**BEFORE the HEARING EXAMINER for the
CITY of MERCER ISLAND**

FILE NUMBERS: CAO15-001 & VAR18-002

TYPE OF CASE: Consolidated: 1) Critical Areas Reasonable Use Exception to construct a single-family residence and associated improvements within a regulated wetland and required wetland and stream buffers; and 2) Variance from the setback requirement from an access easement

EXAMINER DECISION: REMAND

Wetland and Wetland Buffer Impact Site Plan

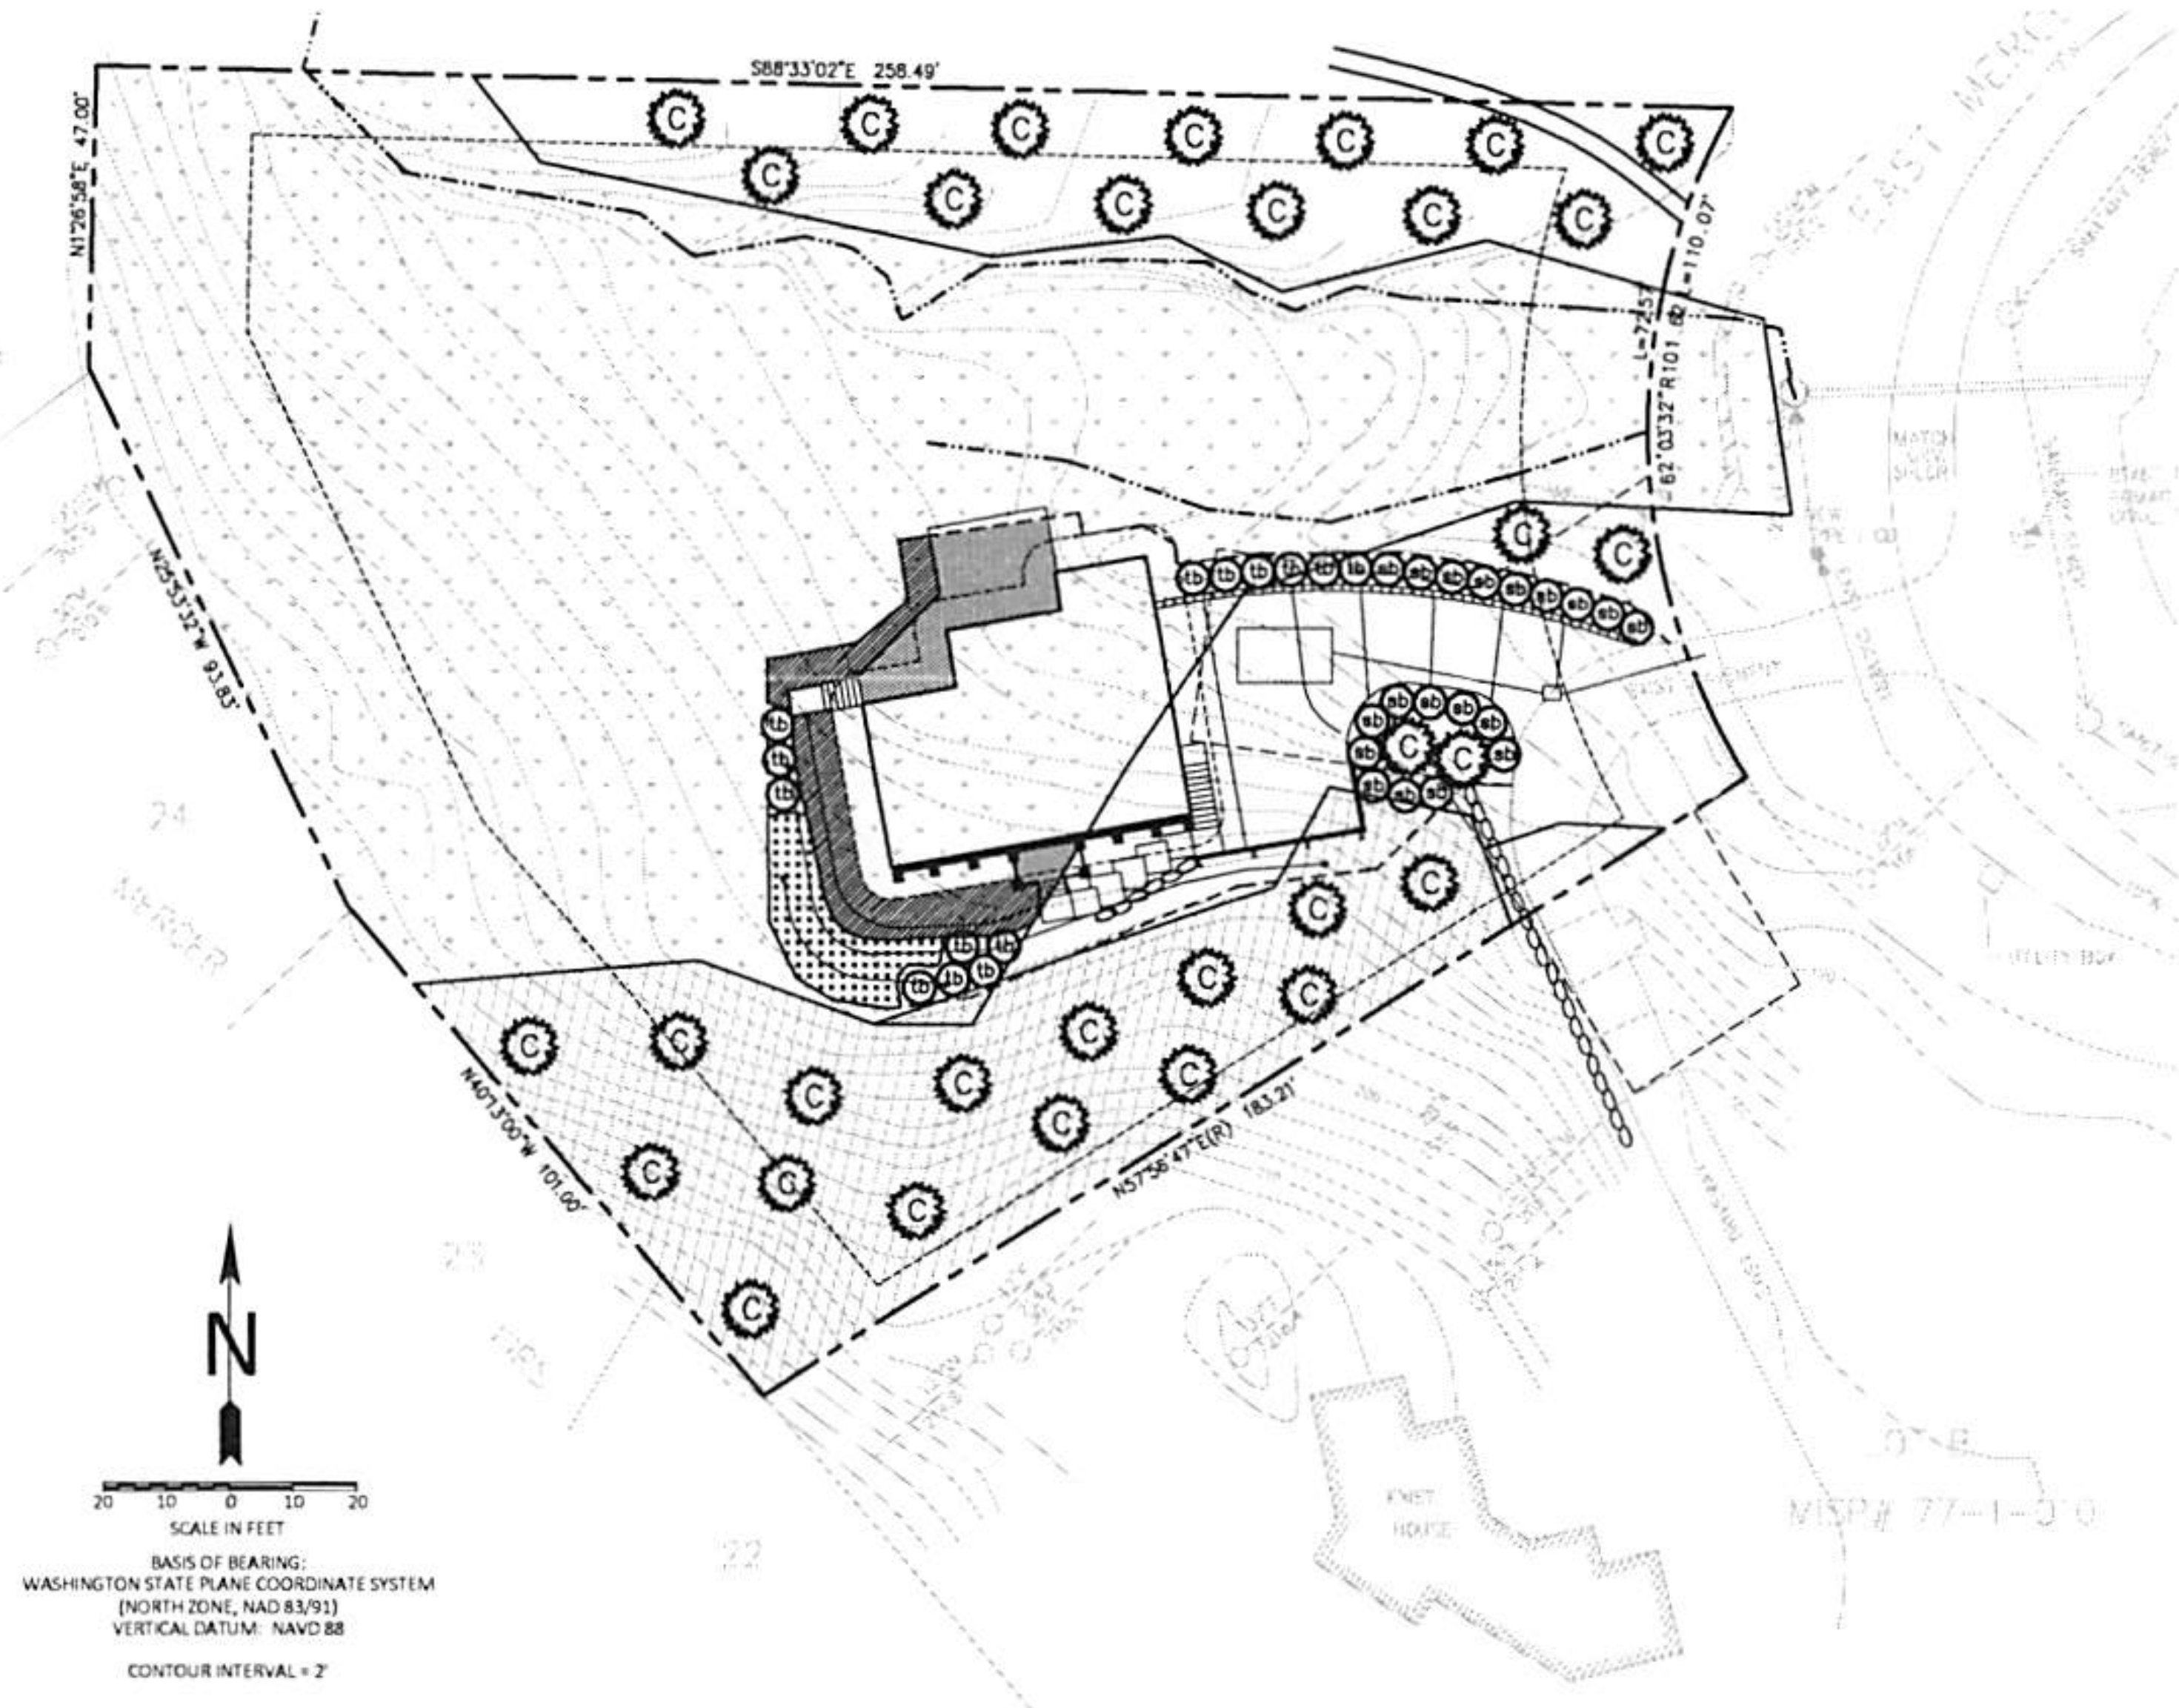
15. Stream B is depicted in various locations and with various lengths on the maps and plans contained in the record. (Exhibits 12b, PDF pp. 3 & 20¹⁰; 12c, PDF p. 7; 38; 42d, PDF p. 5) On the latest project plan (Exhibit 38) Stream B defies geographical logic: It is depicted as flowing diagonally down the shallow side wall of a small, on-site draw. Streams simply do not do that in the real world.¹¹ Streams flow down the centerline of draws or ravines, not slaunchwise down their sides. If the topography on Exhibit 38 is accurate and if Stream B were properly mapped, it would originate at or flow beneath the northeast corner of the proposed residence, depending on its length. By drawing Stream B on the side of the slope, it misses the house by about seven feet. (Exhibit 38)
